**Proposed Mixed Commercial and Retail Development,
Stages 1A and 2, Site 43/44, Sydney Olympic Park
(SSD 12_5676 and SSD 12_5677)**

October 2013

Response to Submissions Report

GFA PLANS

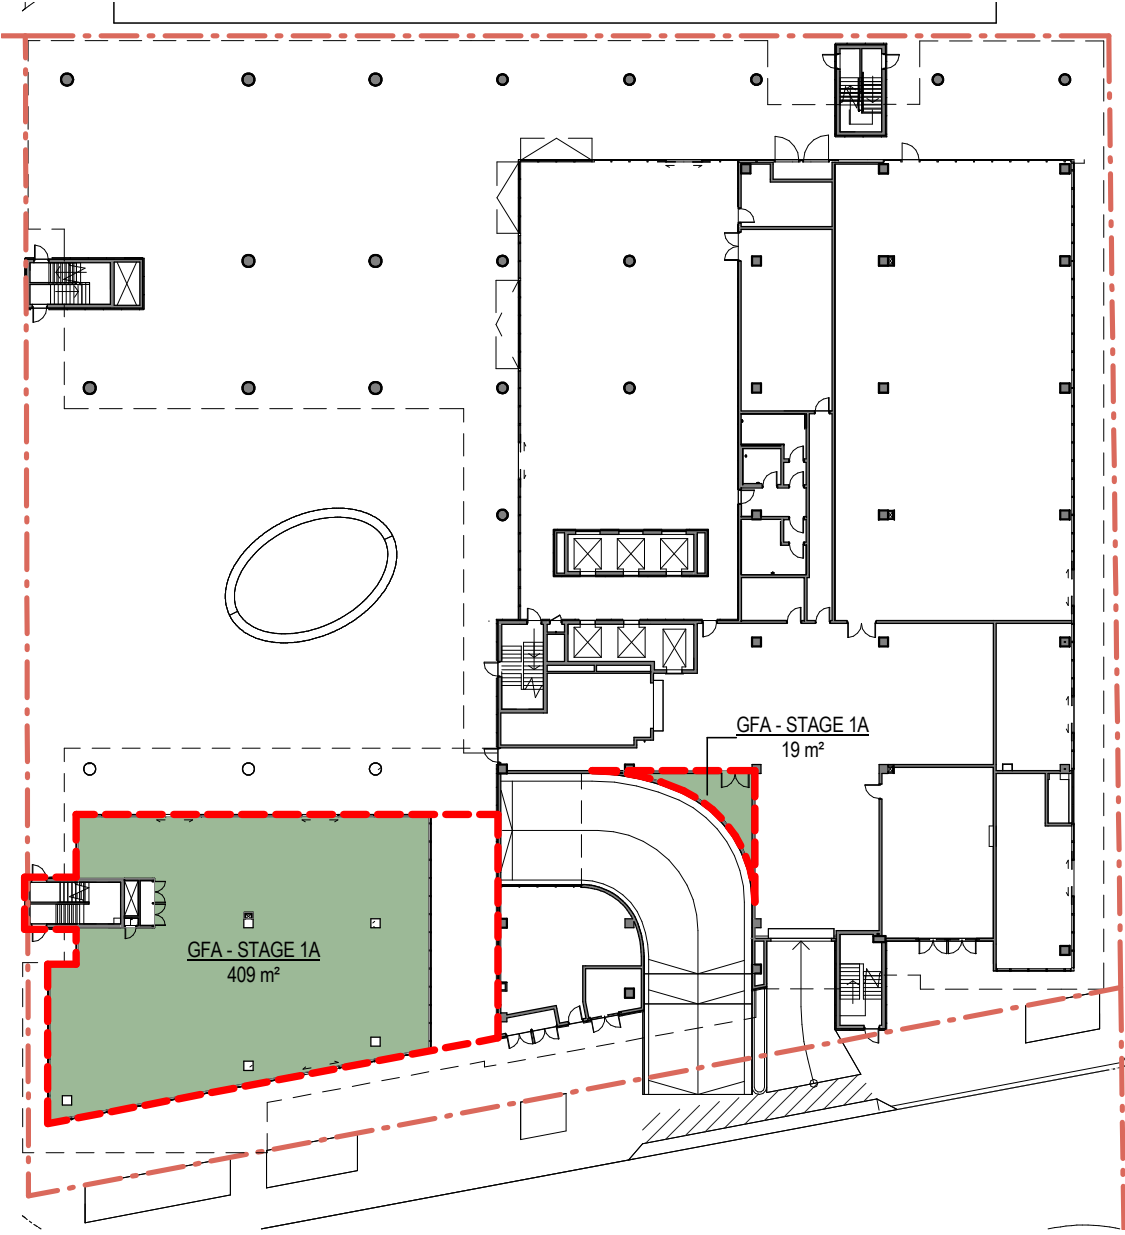
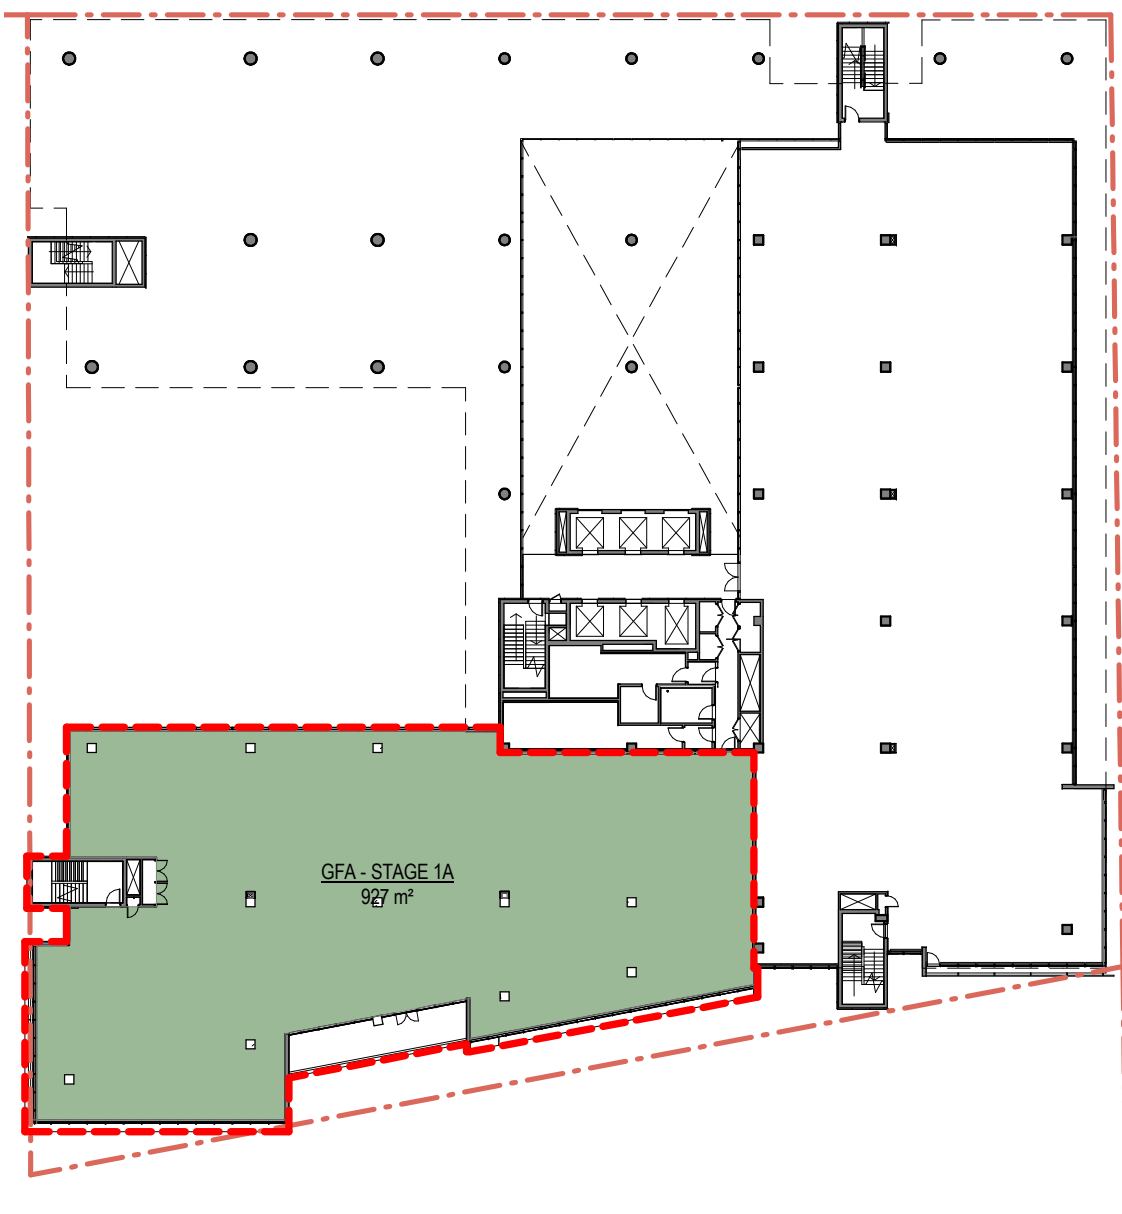
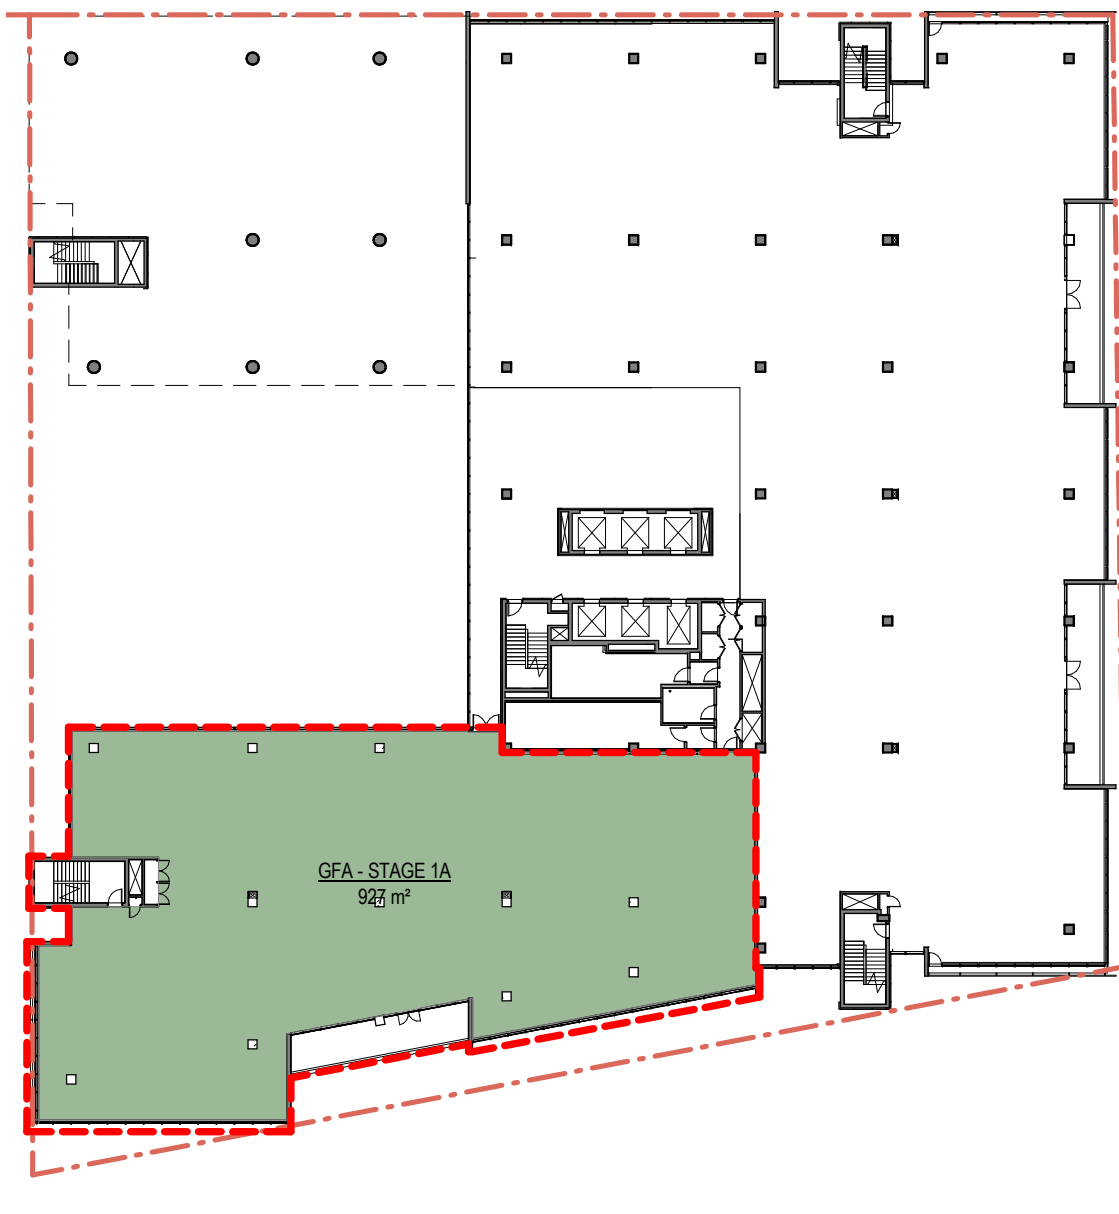
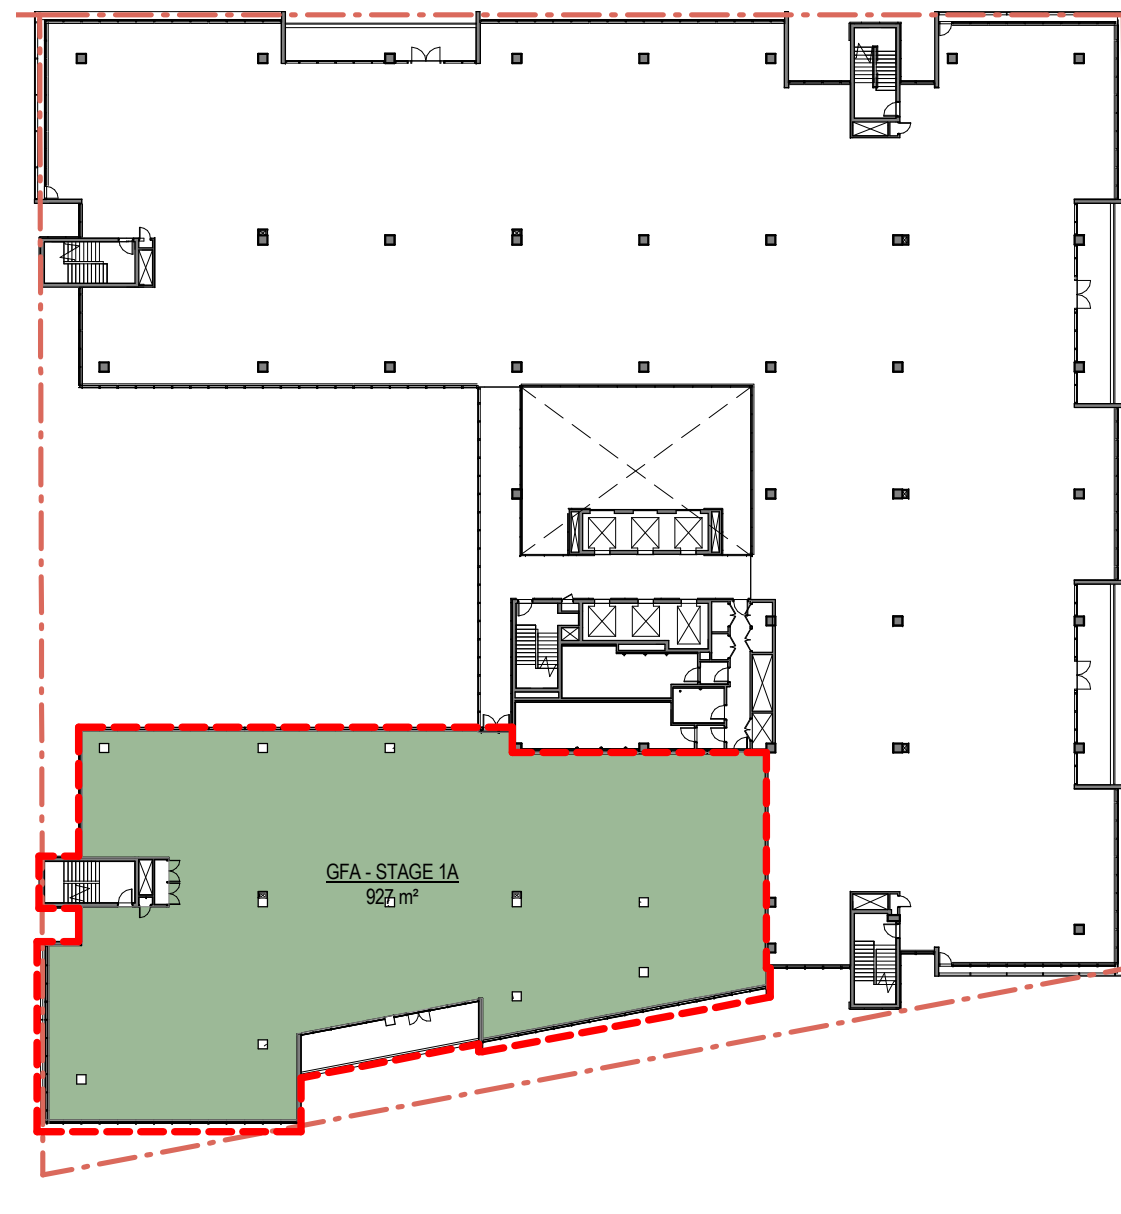
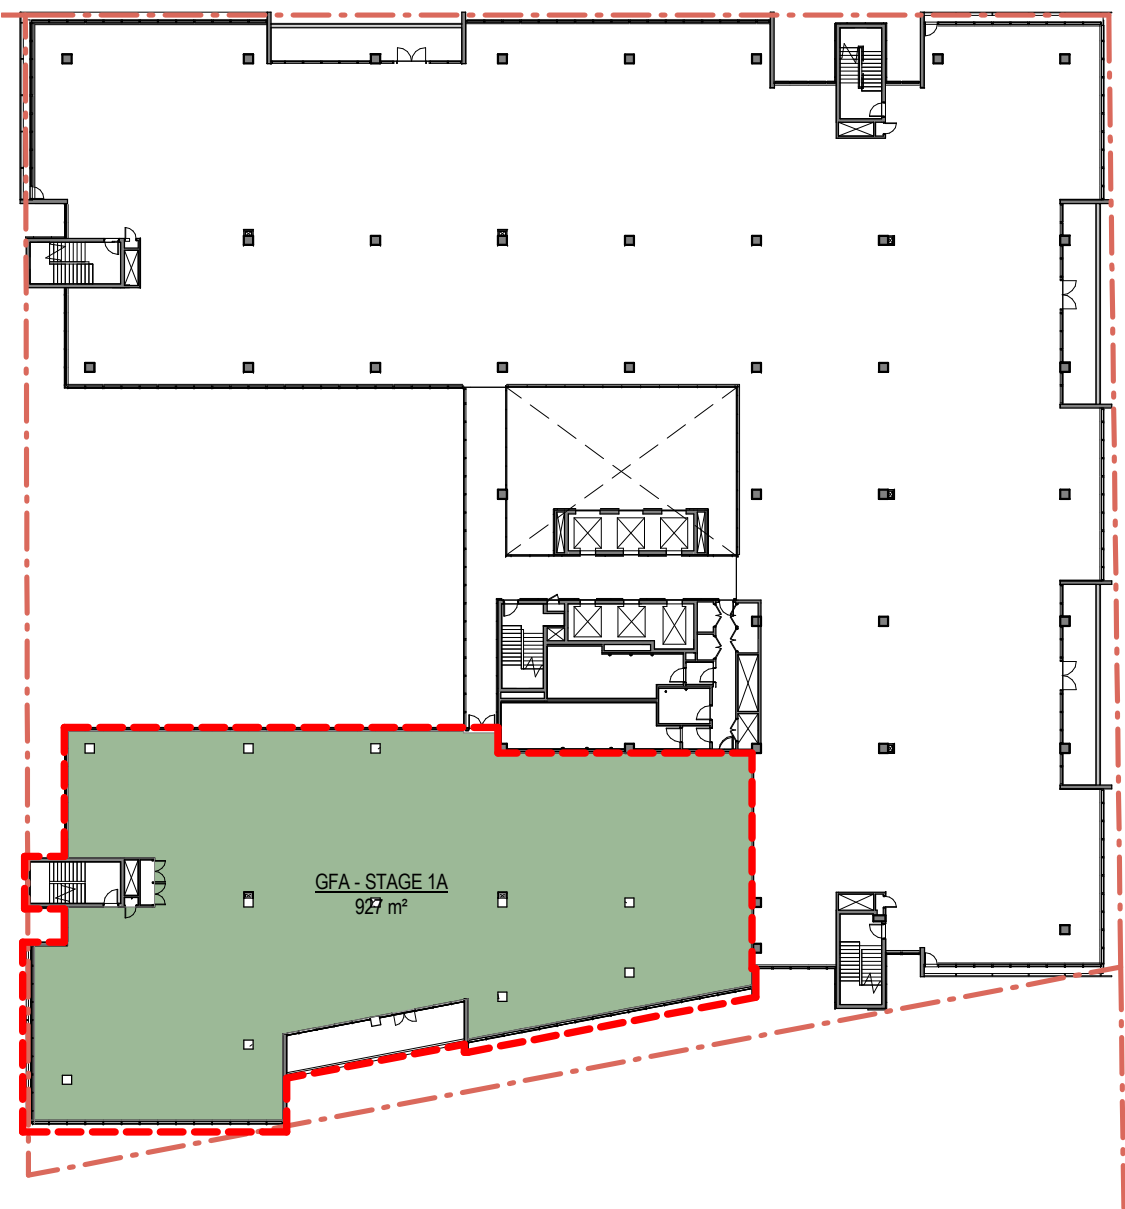
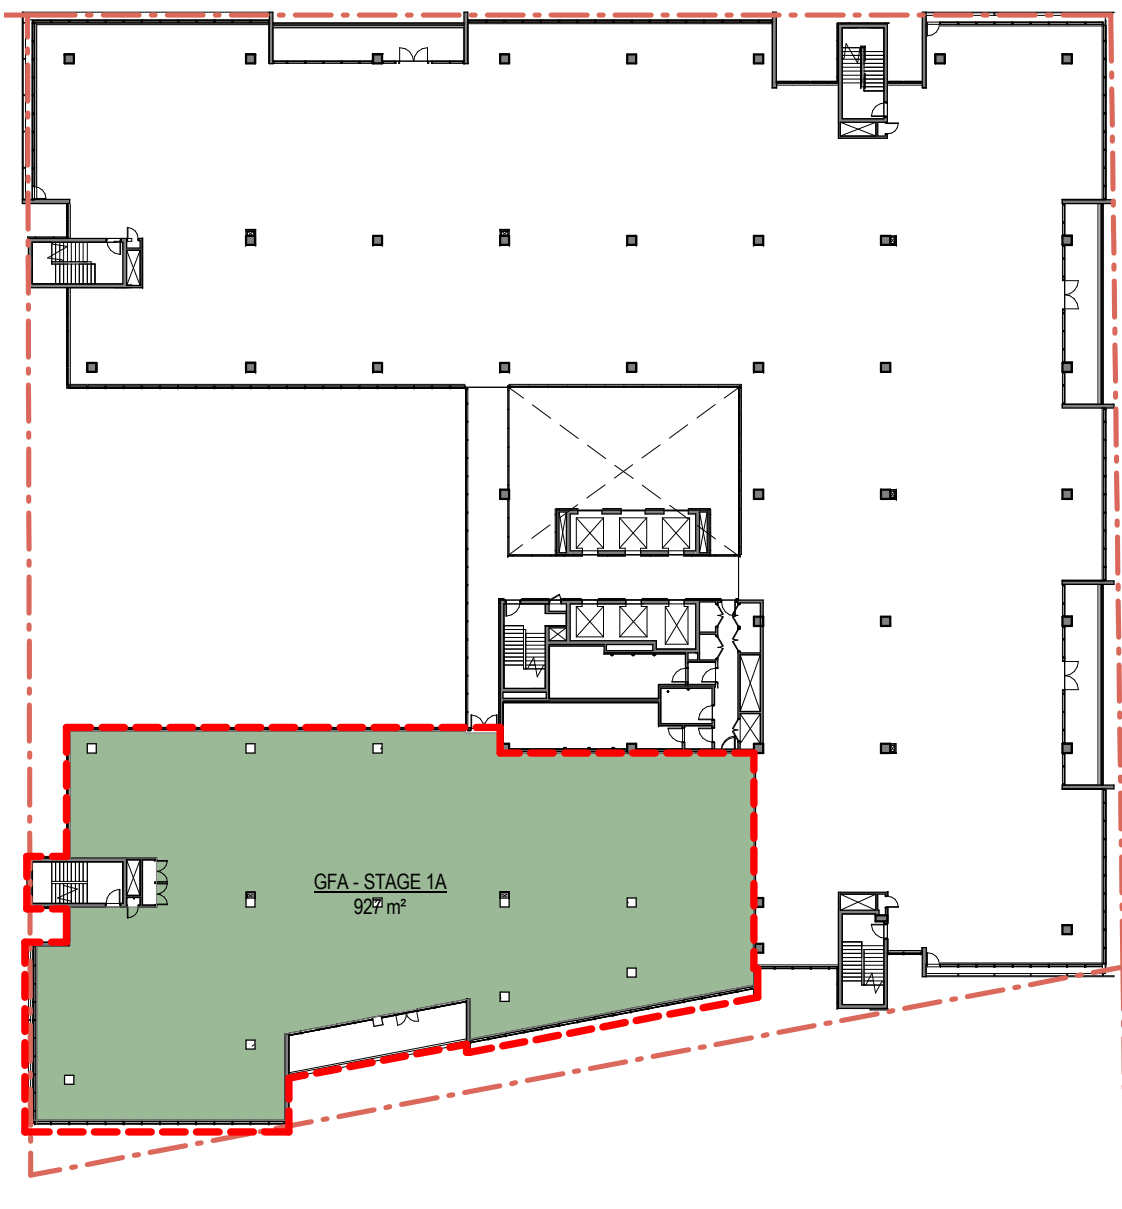
In addition, there is a slight change to the Gross Floor Area for Stage 1A from 6,920m² in the EIS supporting the SSD application, to 6,917m² in this Response to Submissions Report. The 6,919.7m² GFA is comprised of 6,489m² commercial GFA and 428m² retail GFA, with retail Net Leasable Area (NLA) of 409m². The architectural drawing showing the GFA schedule for Stage 1A has been amended to reflect the amended total GFA – refer **Attachment A**.
